Planning Application reference: 76795/APP/2021/3704

This Document has been prepared by Hunters to support the planning application for minor amendments proposed to the Yiewsley Housing and Library Scheme.

**YIEWSLEY LIBRARY SITE  
PROPOSED SITE PLAN**

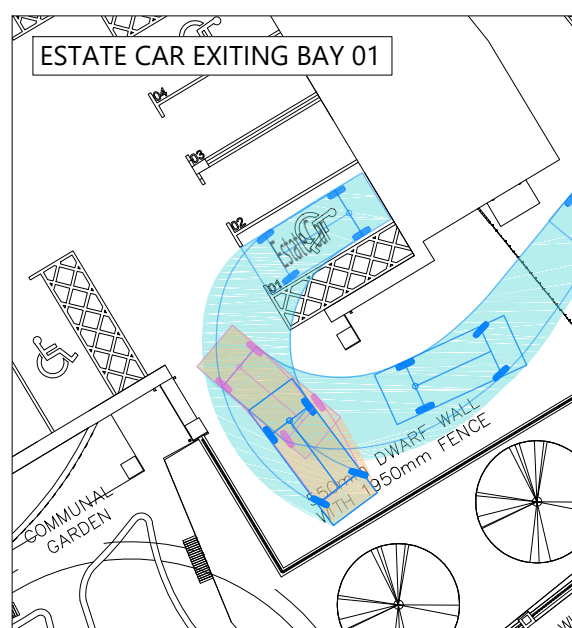
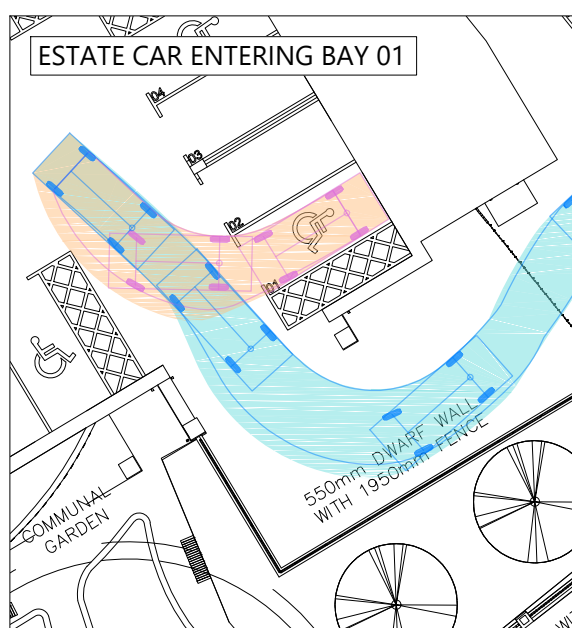
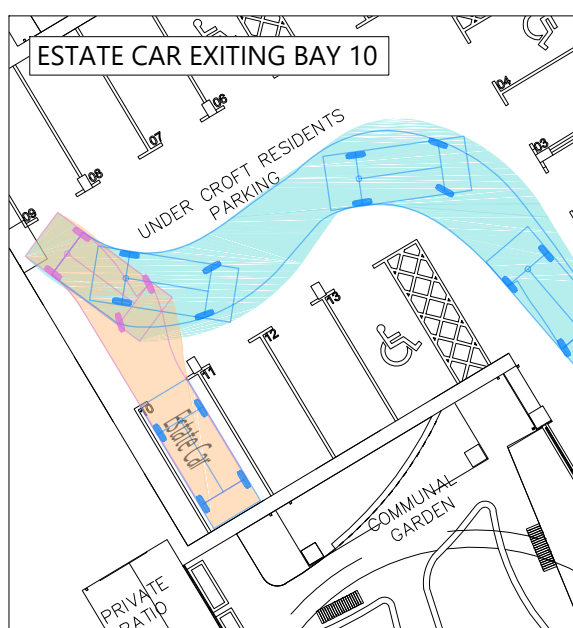
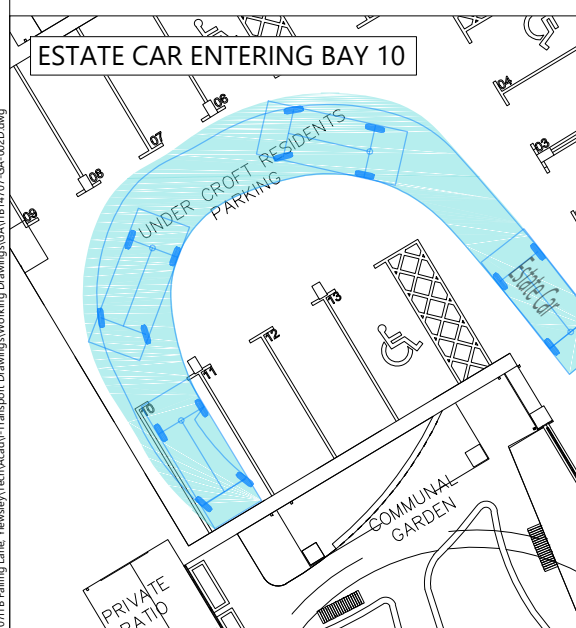
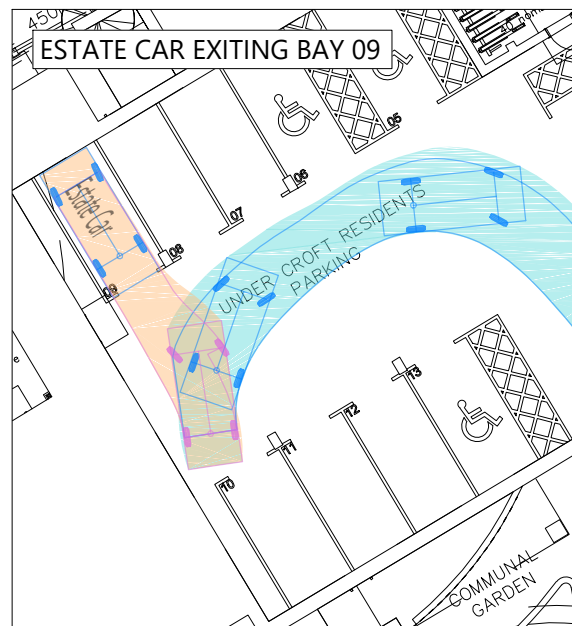
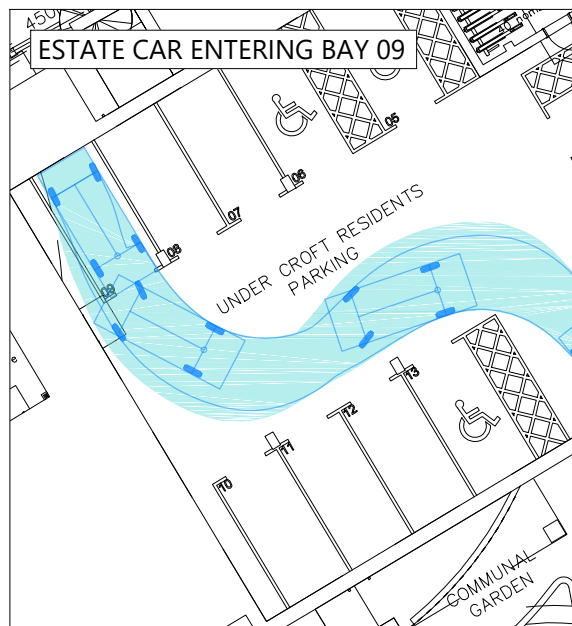
- An accessible parking space should be allocated to each of the required wheelchair accessible/adaptable dwellings, with a 1200 mm wide transfer area provided alongside. These units should be interspersed throughout the development, and each should be served by two lifts.

In both sites, designated parking spaces are provided for each wheelchair user unit. 1200mm transfer area provided in line with Part M of the Building Regulations.

Yiewsley Library site:
